Our ref: SSD-50972718

Subject: Request for Additional Information - Wallgrove Business Hub (SSD-50972718)

Attachment 1 – The Department’s Comments

Figure 5: Concept Masterplan

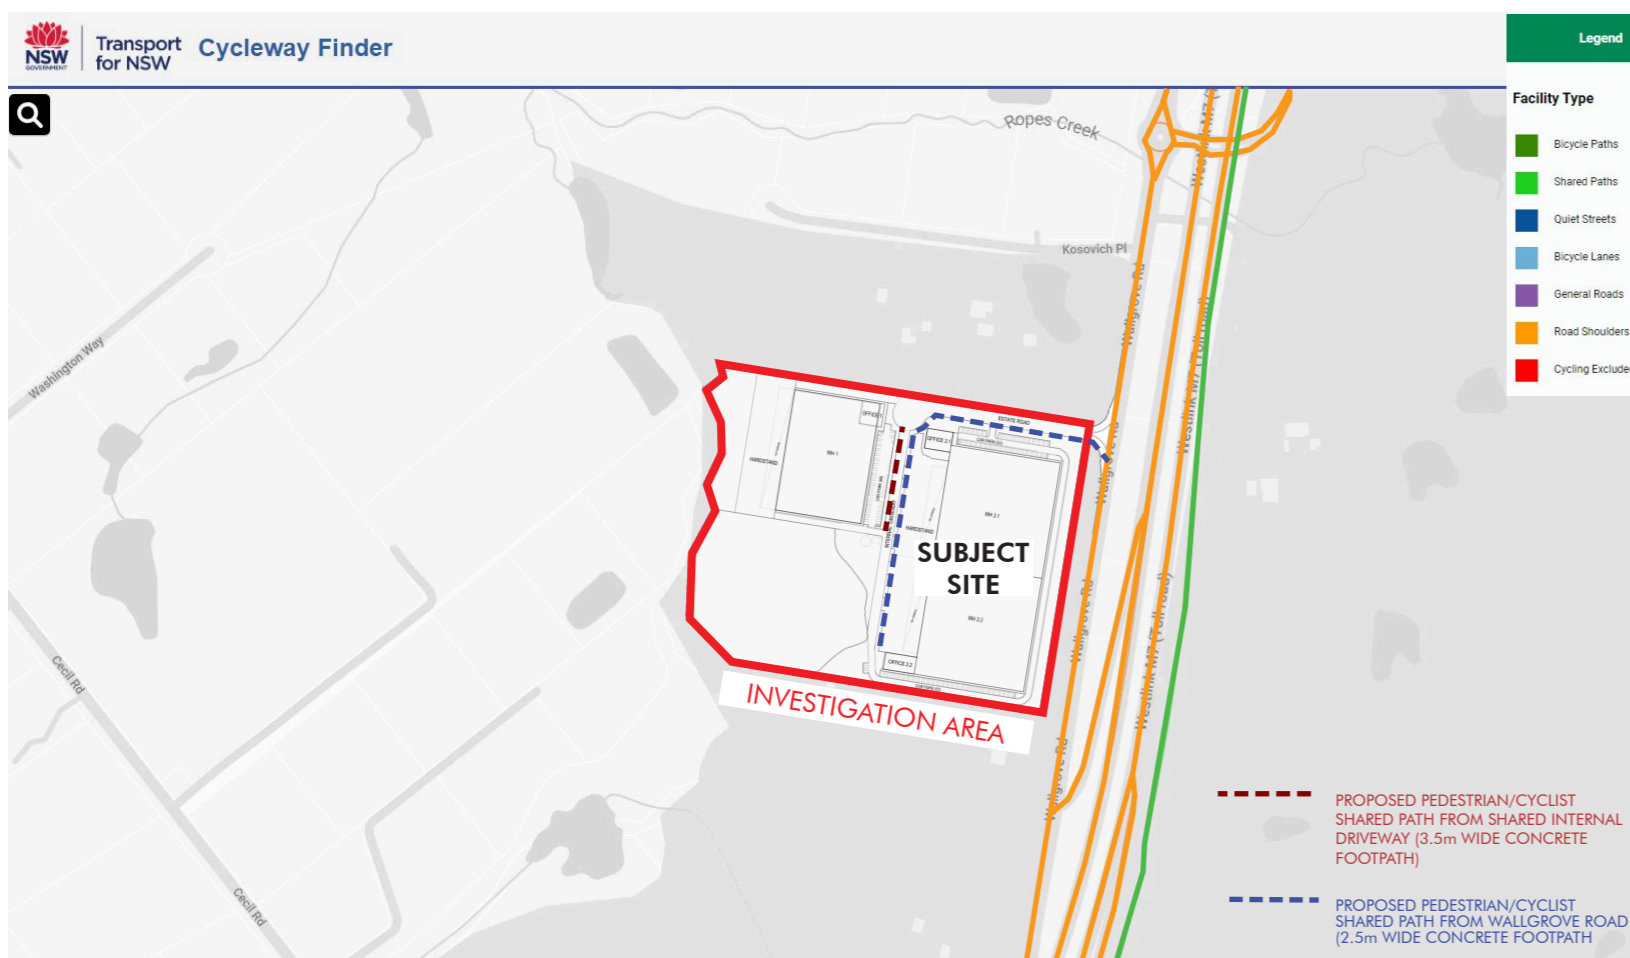
5. The updated bushfire assessment indicates a continuous perimeter access road around both buildings. However, the concept master plan does not show a connection between the two lots,

which conflicts with the access route identified in the bushfire assessment. Please either update the master plan to include this connection or revise the bushfire assessment to accurately reflect the proposed access arrangement.

Drawing Title:
Landscape Sections
DWG No:
SSD-06

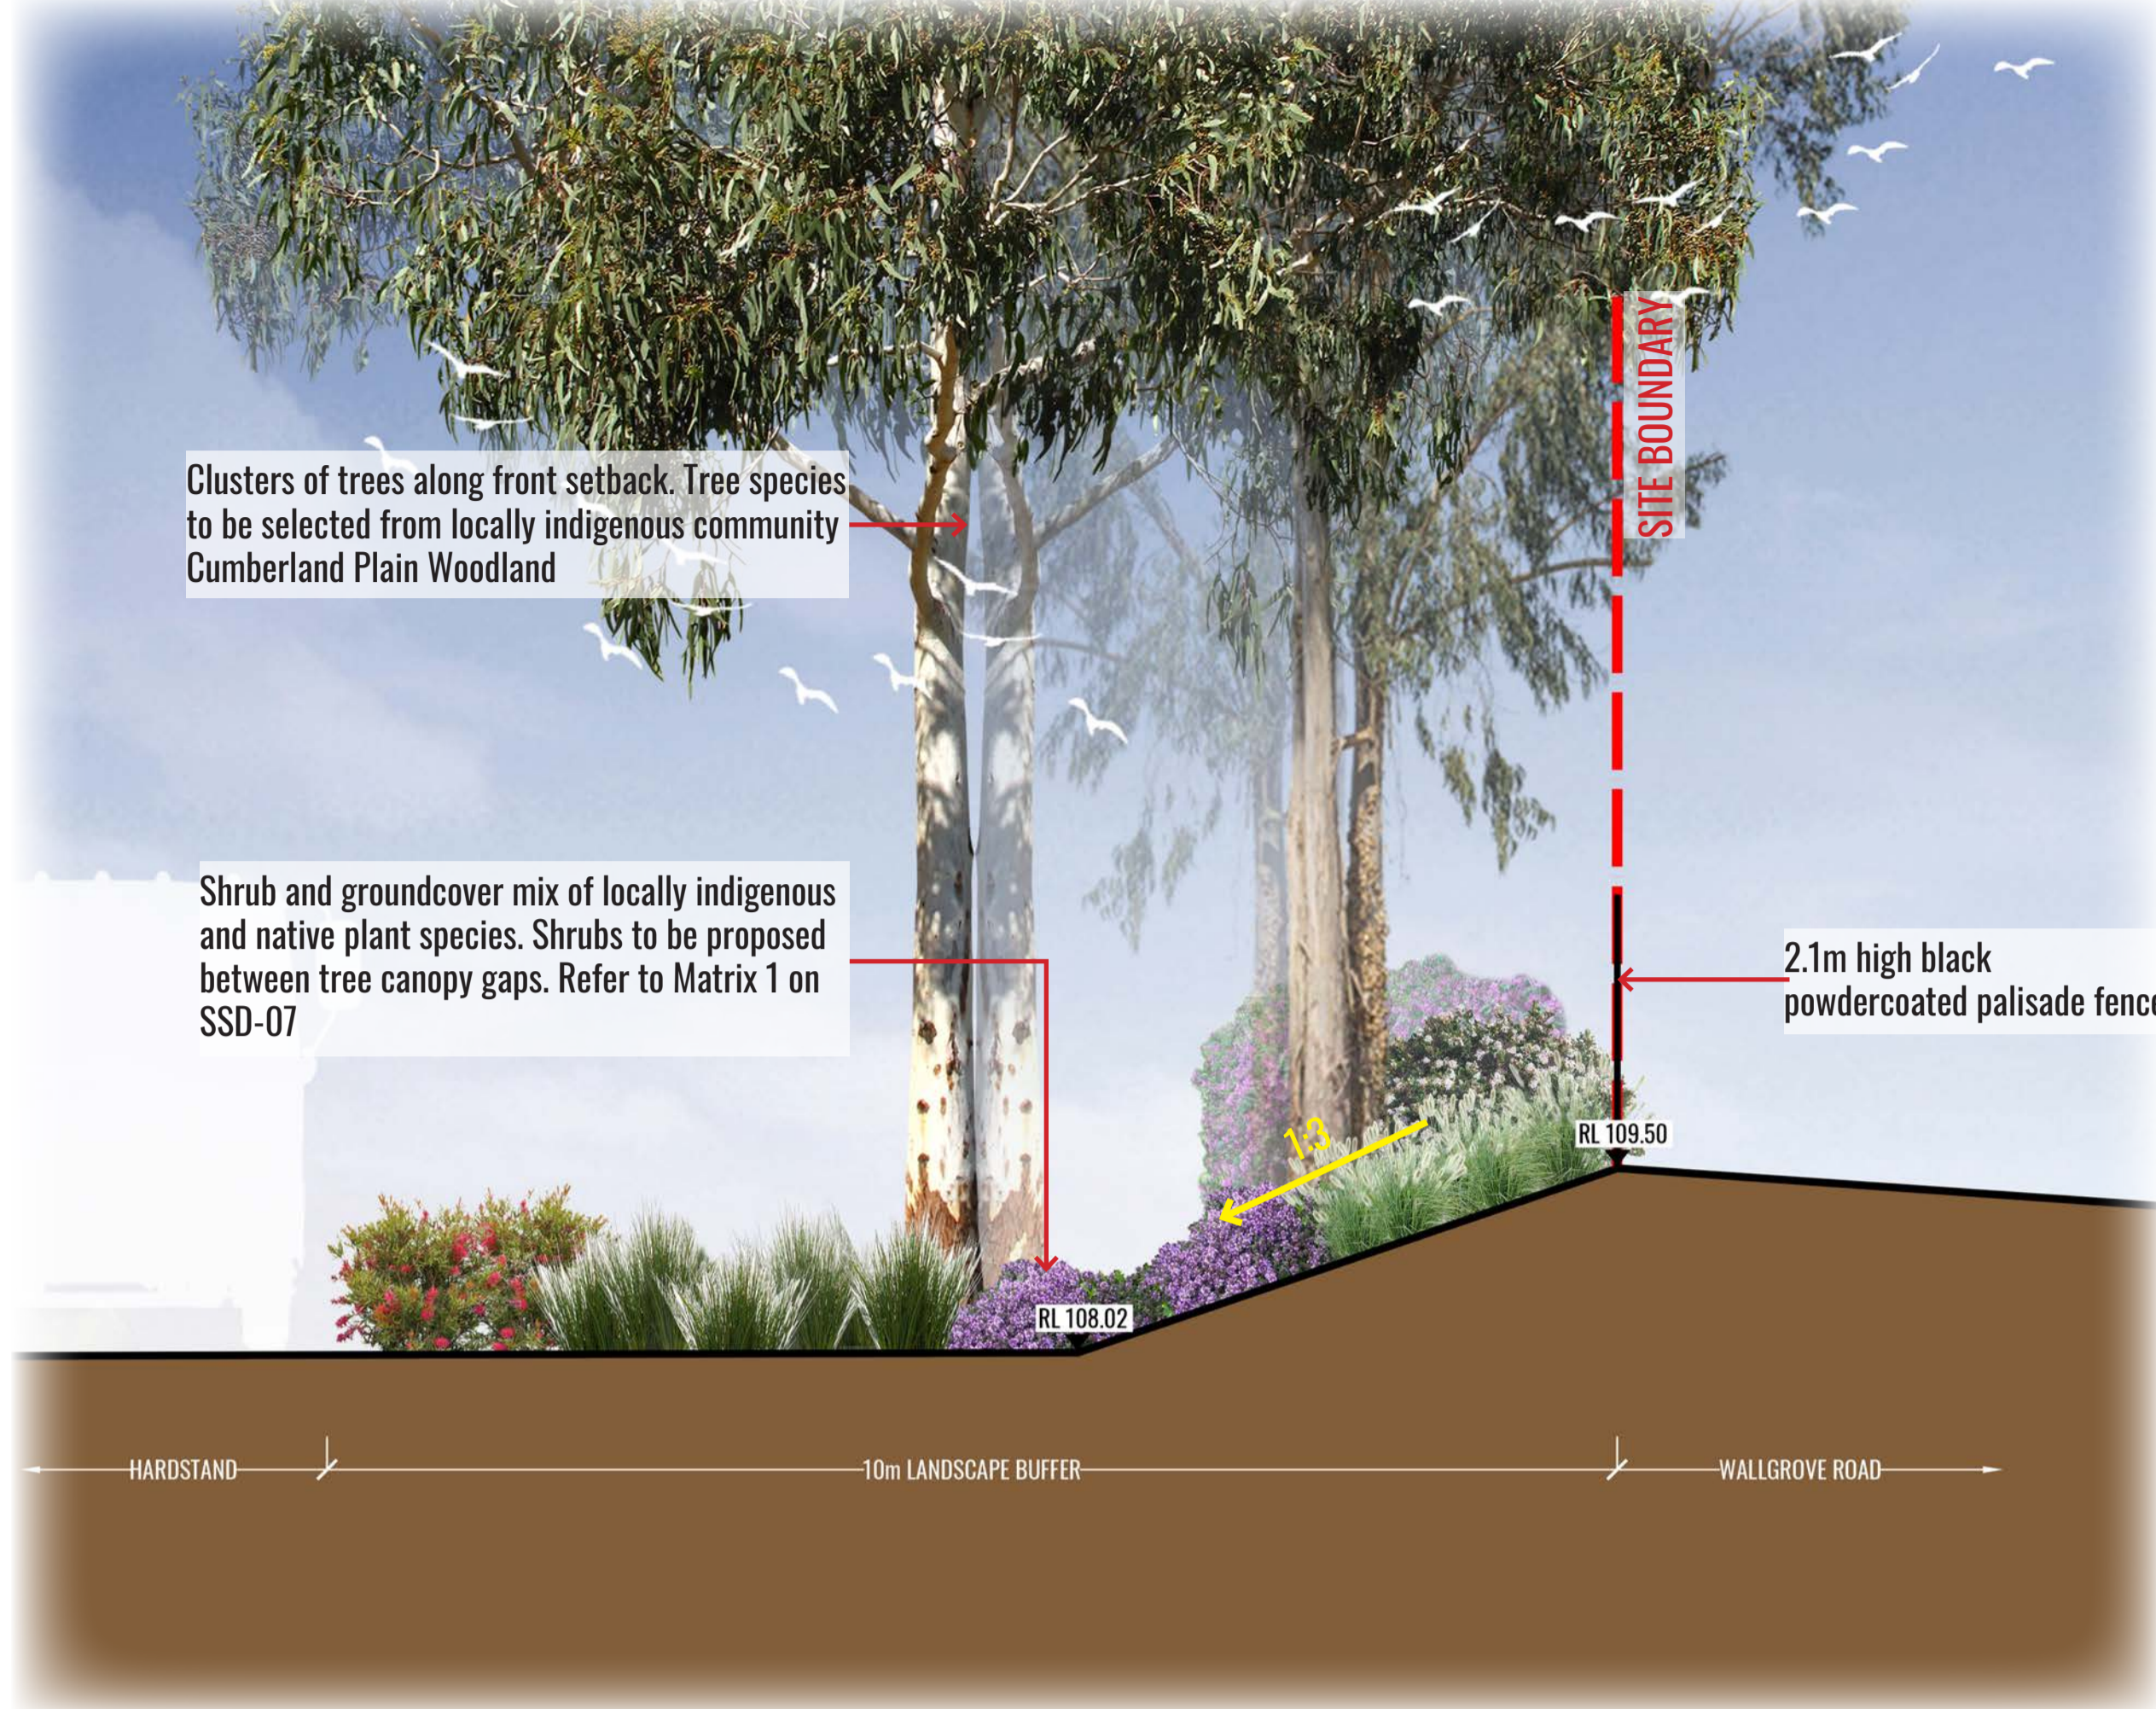
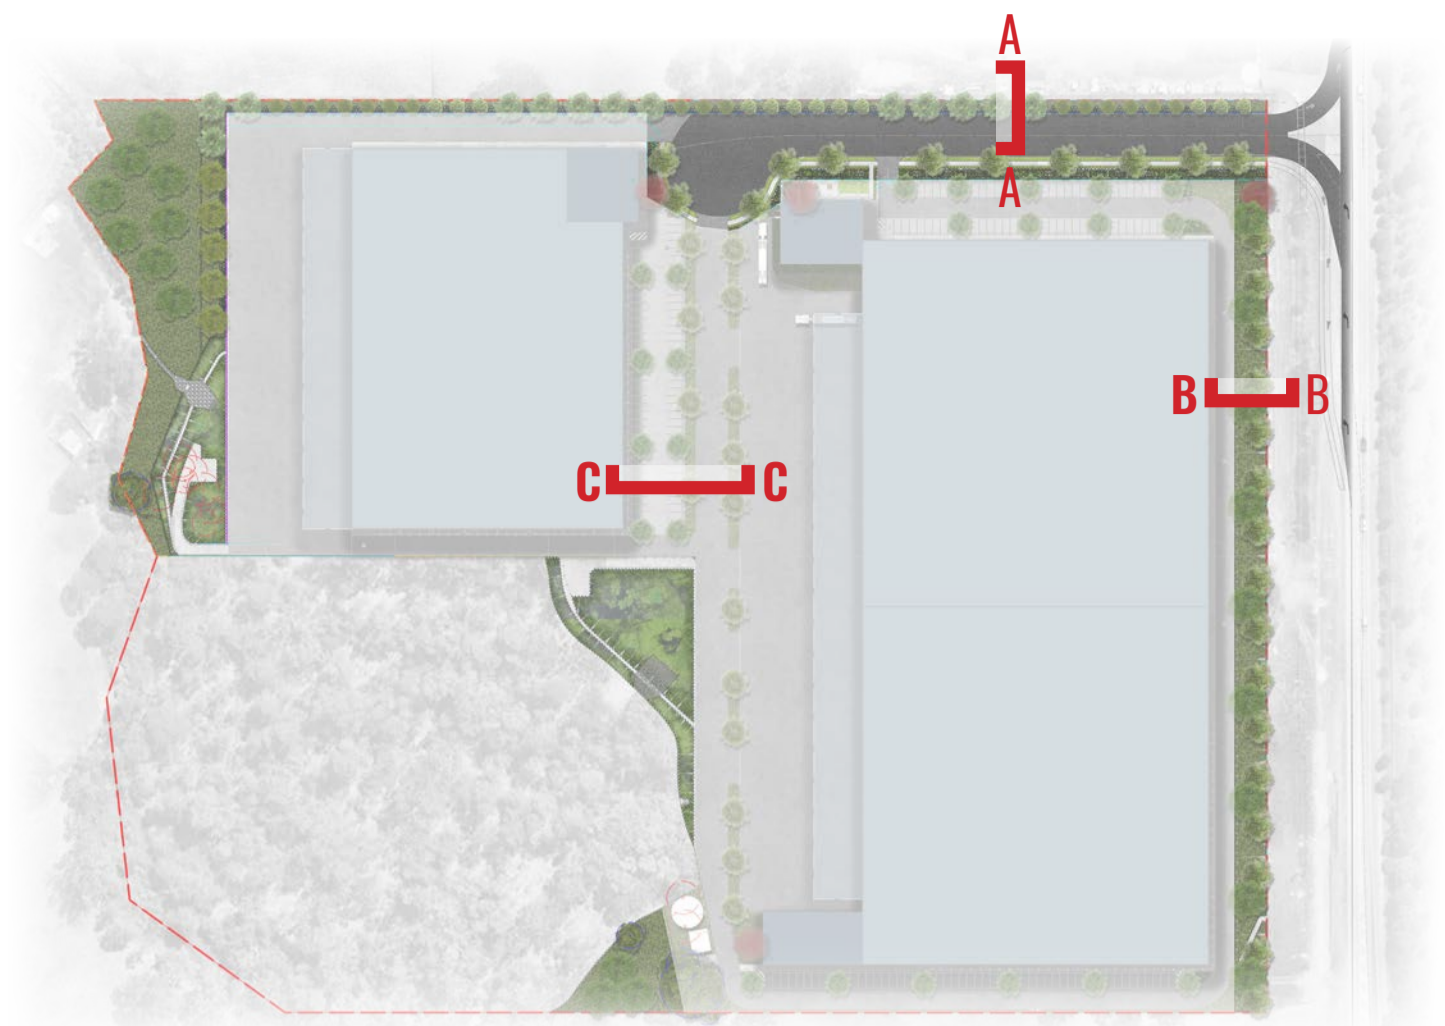
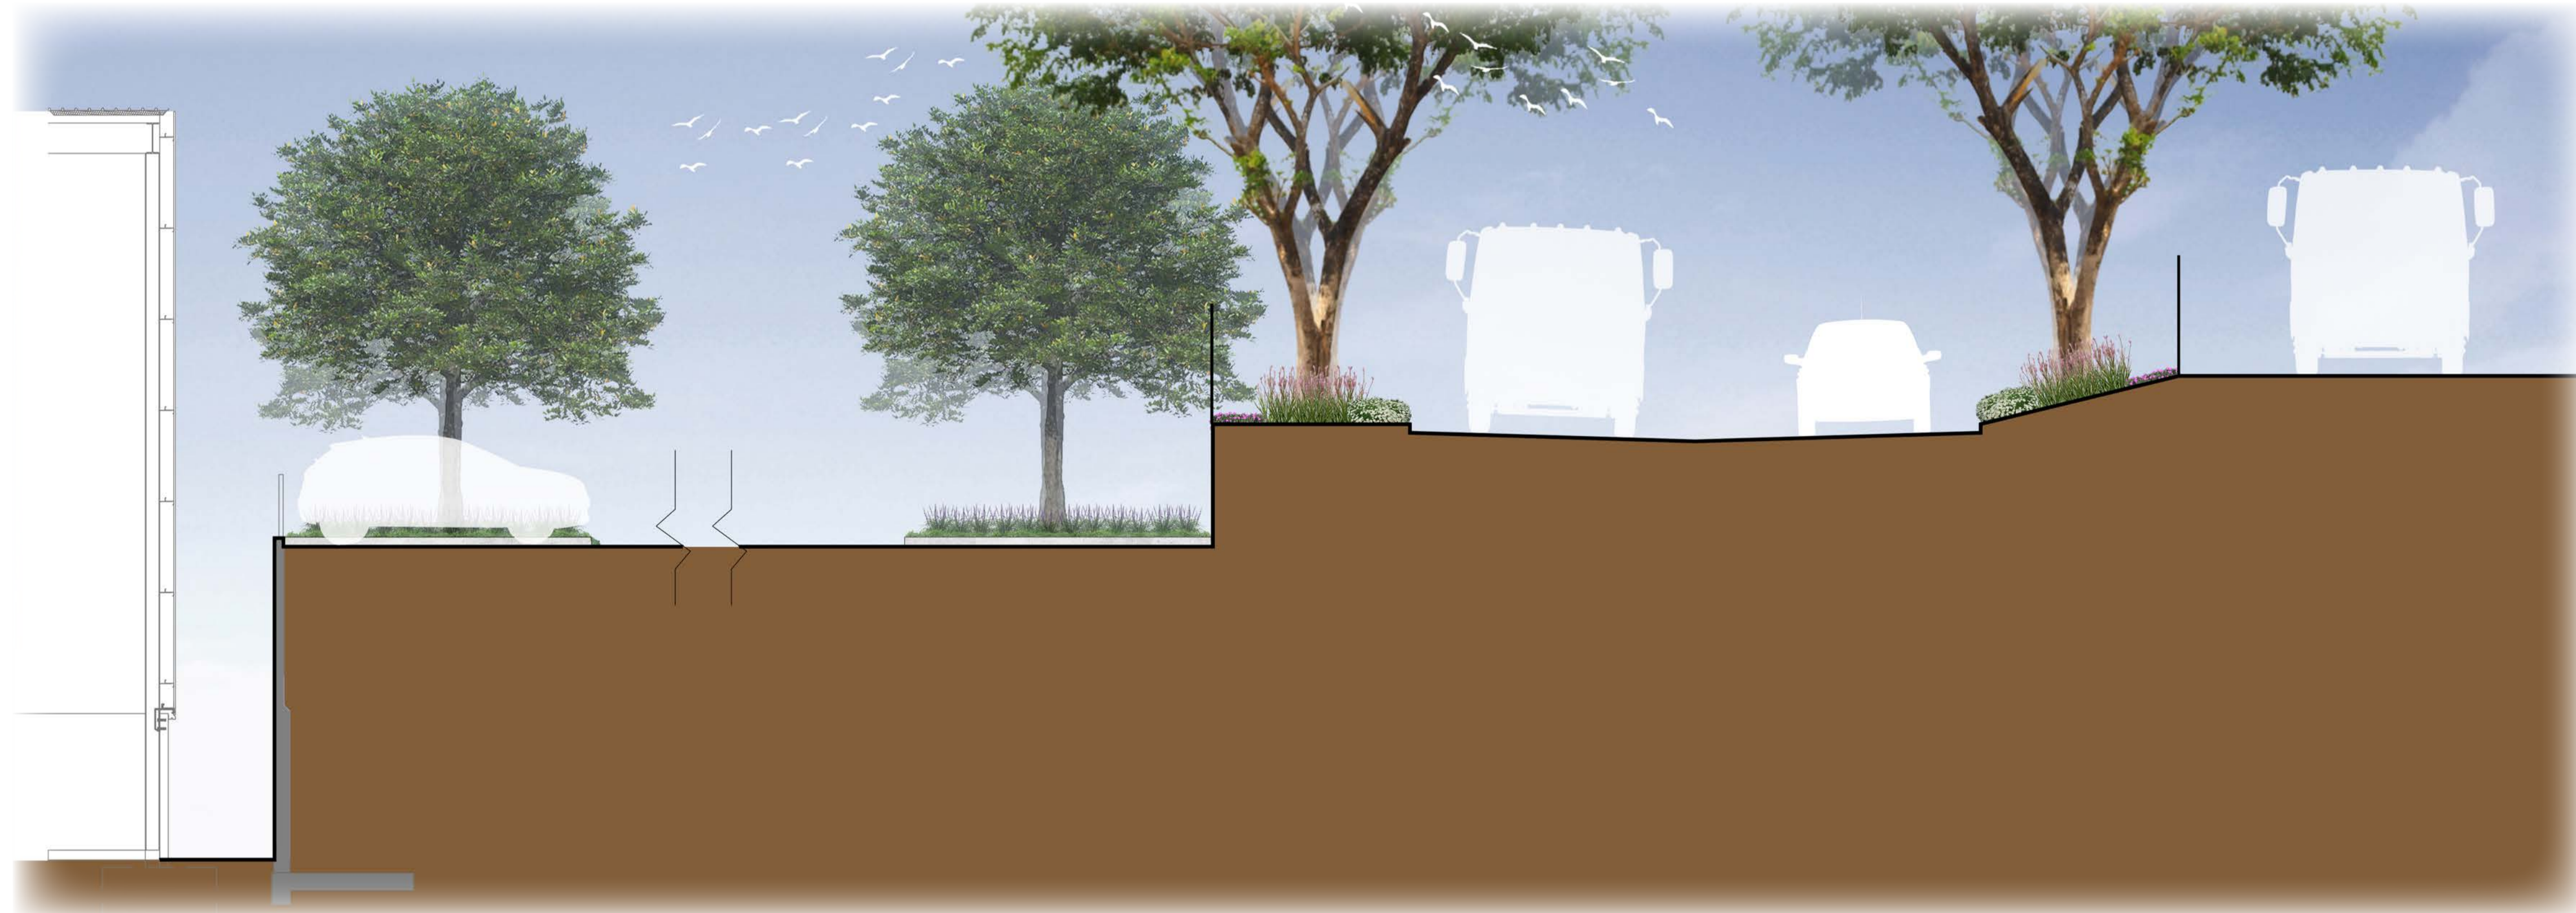
1. The Department acknowledges that the proposed changes help to soften the appearance of Warehouse 1 from the northern and western viewpoints, as outlined in the Visual Impact Assessment. However, the Department remains concerned that the lack of landscaping adjacent to the western elevation of the warehouse results in the façade appearing highly prominent when viewed from sensitive receivers to the west. This visual impact is further exacerbated by the warehouse’s considerable bulk and scale.

Accordingly, the western elevation should be reviewed with a view to providing increasing visual screening of the building. This should include consideration of providing additional landscaping on the uppermost tier of the retaining wall.
